### APPLICATION CONSULTATION RESPONSE

<b>Application Number:</b>	3/2019/0661
<b>Location:</b>	Land at Petre Wood Close, Langho, BB6 8FE
<b>Proposal:</b>	31 affordable two and three-bedroom houses and two-bedroom bungalows (for rent and for shared ownership).

#### **Lead Local Flood Authority (LLFA) Position:**

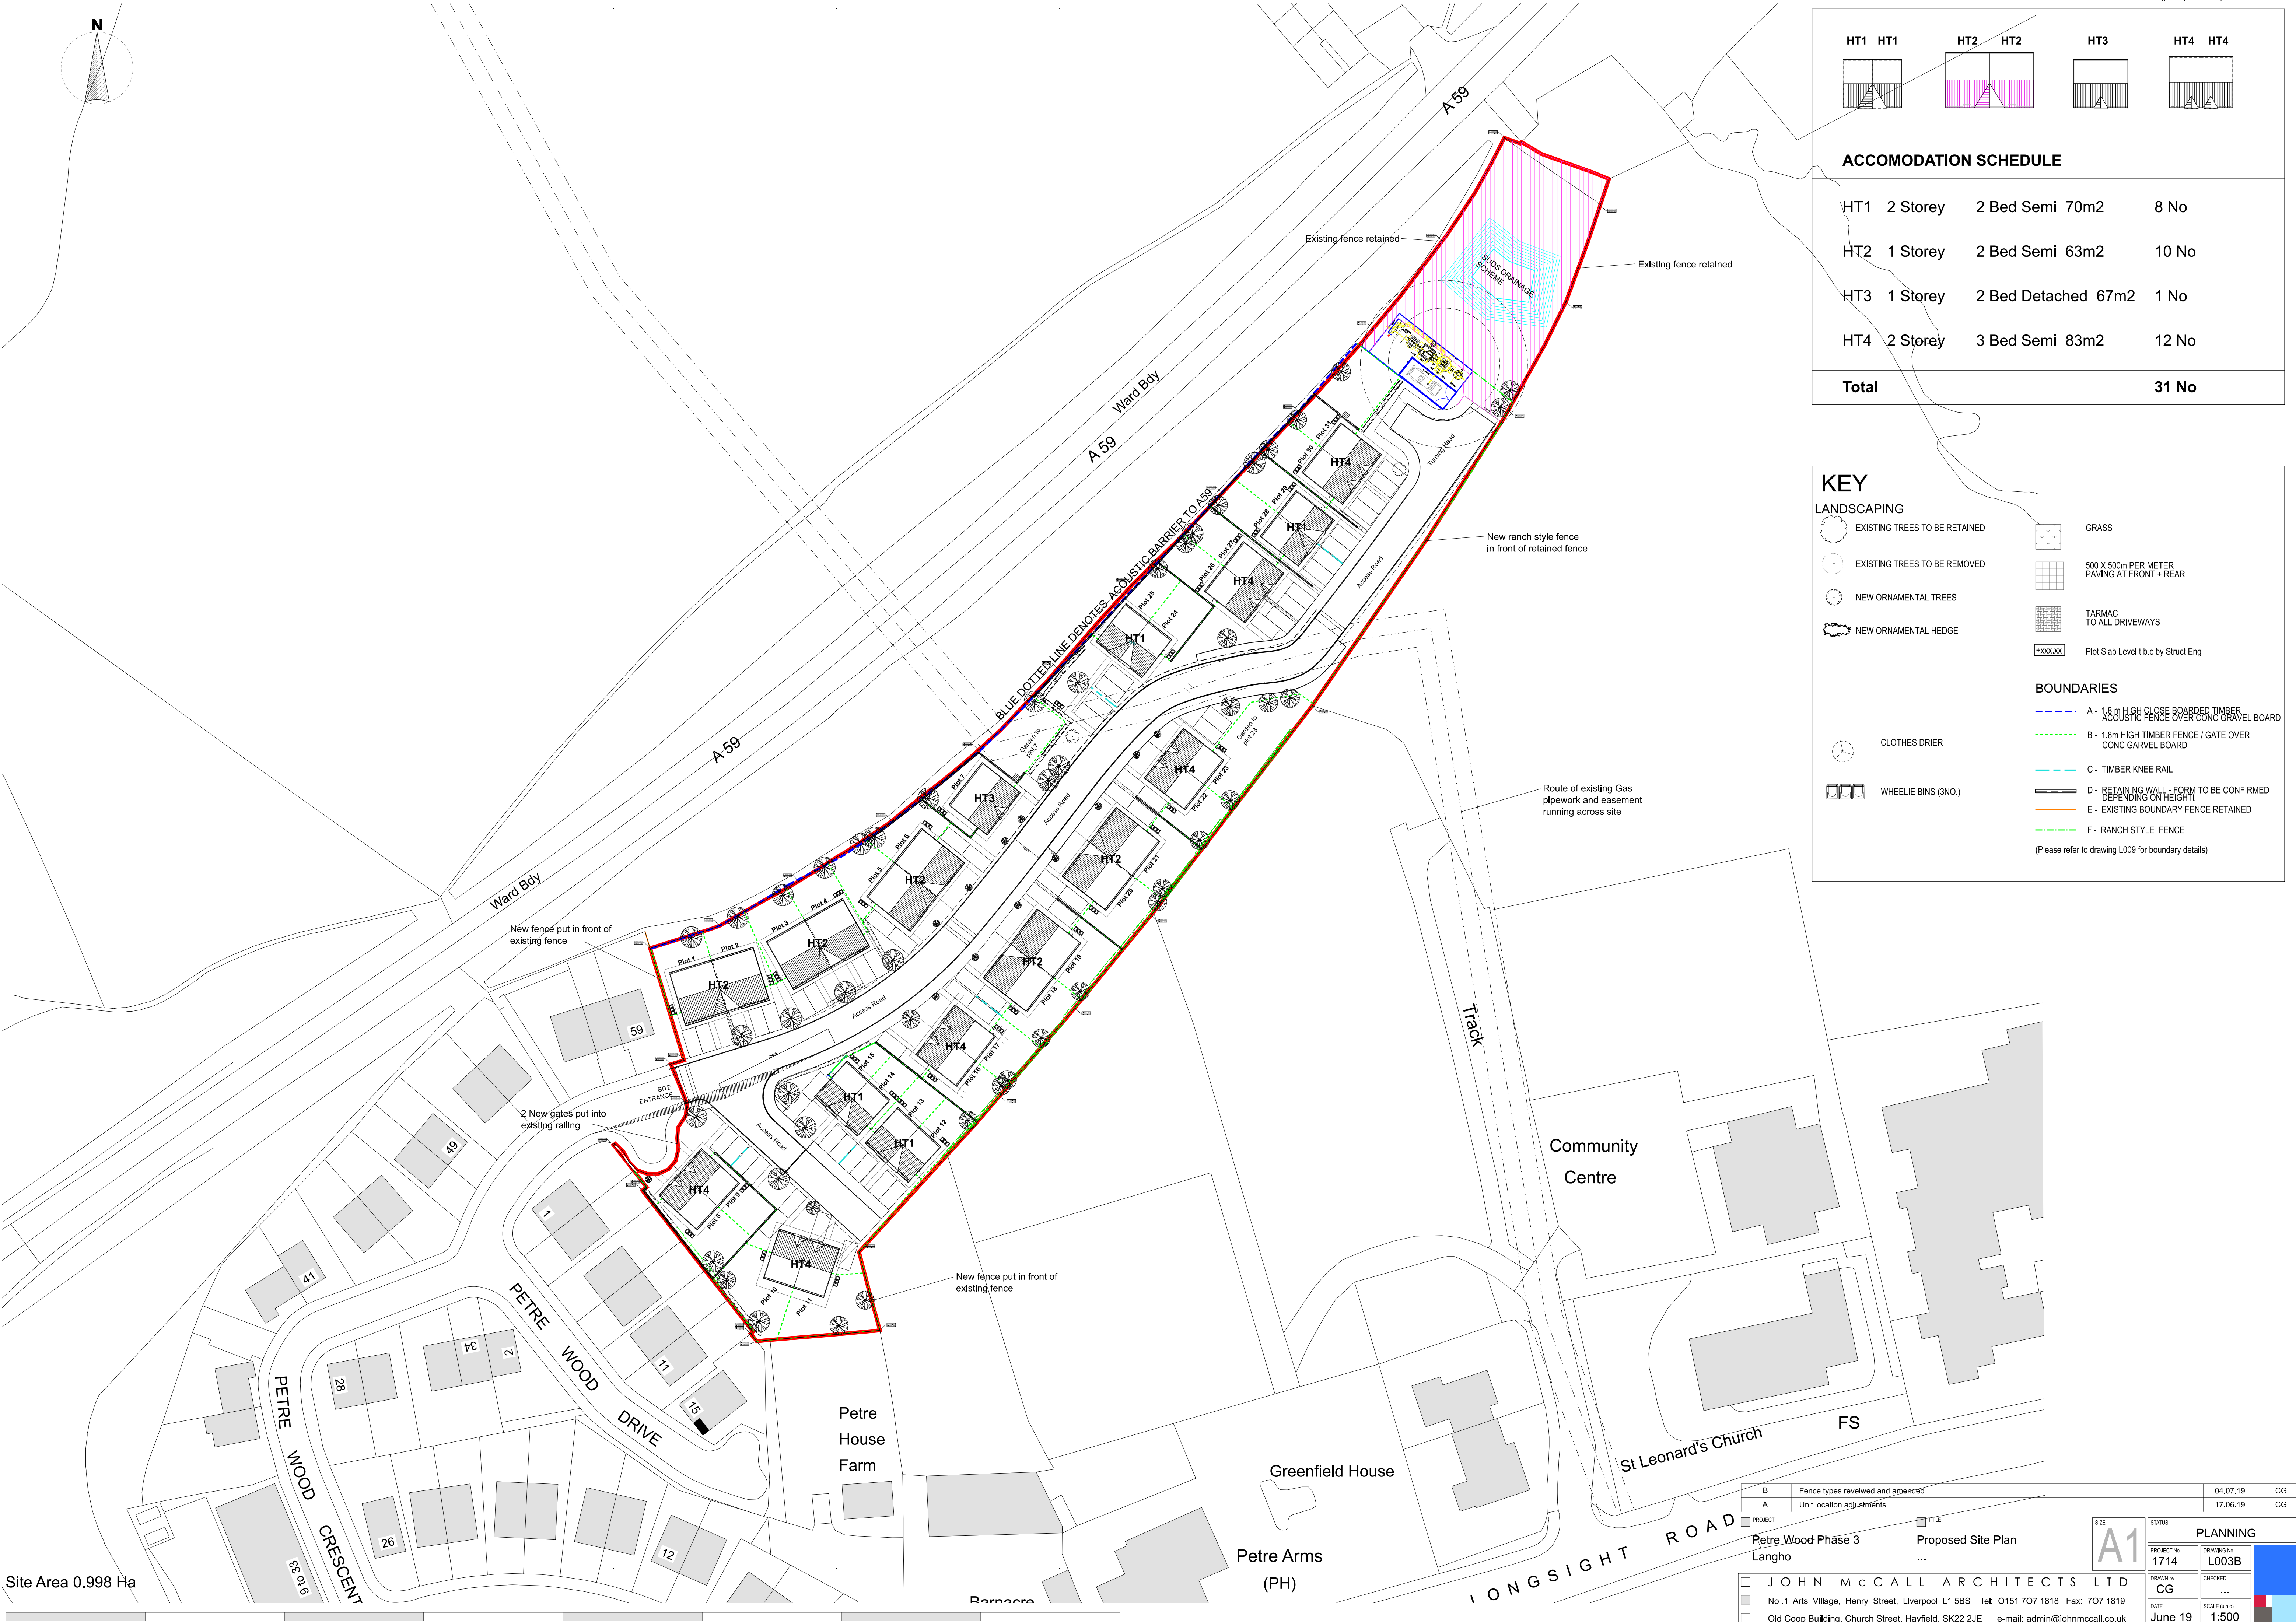
Whilst the above development is stated as being less than 1 hectare on the application form, we note the difference is only 100 square meters which gives a very small margin for error. We would therefore recommend for the Local Planning Authority to check the total site area of the site to ensure compliance with the requirements of the NPPF. If the total site area is considered to be 1 hectare or more, then the application should be supported by a site-specific FRA in line with the requirements of the NPPF.

It is evident from the outline drainage layout that the applicant intends to discharge surface water to an existing ordinary watercourse that is located roughly 19m beyond the north eastern boundary of the site. In order for this to be considered acceptable, the applicant will first need to provide evidence or justification to demonstrate why other higher priority discharge options, namely into the ground (infiltration), are not reasonably practicable in line with the drainage hierarchy in the Planning Practice Guidance.

The LLFA would also recommend for the red edge boundary of the site to be suitably extended to include the proposed surface water outfall location.
